**From:** Tim Screen  
**Sent:** 08 June 2021 10:20  
**To:** Wayne Campbell  
**Subject:** 21/00500/OUT - Land North Of Railway House, Station Road , Hook Norton

In consideration of the amended landscape response of 14th May from MHP

Amended Landscape Note – Site Access. 26<sup>th</sup> May.

Figure 18 Viewpoint Photograph 9 - Single Frame View
20147 Hook Norton

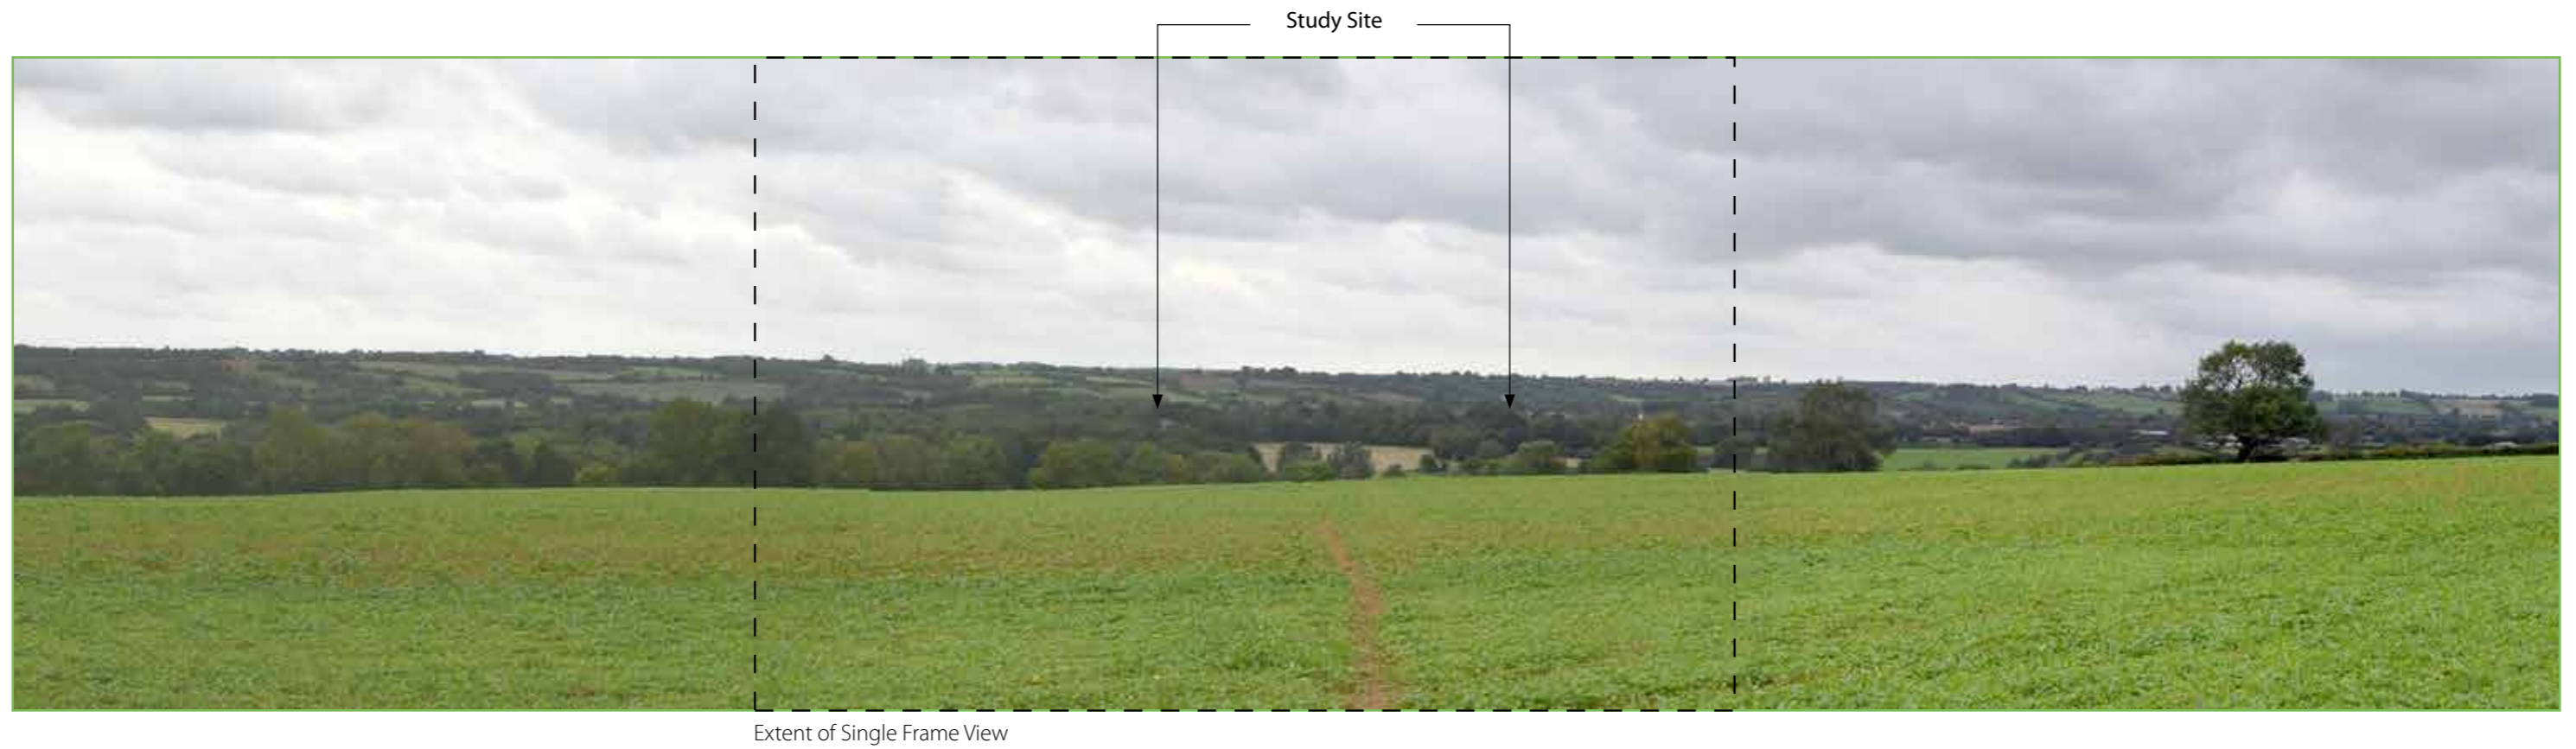
In order to achieve screening of this development the establishment period for these trees (depending on species selected, maintenance, climate and soil) is approximately 25 years. For example the growth rates of feathered trees may achieve a height of 9.5 – 9.7 m at 20 years. This will mean the rooflines will still be clearly seen by the visual receptors at viewpoints 8 and 9 with prolong exposure to visual harm on the route between this viewpoints.
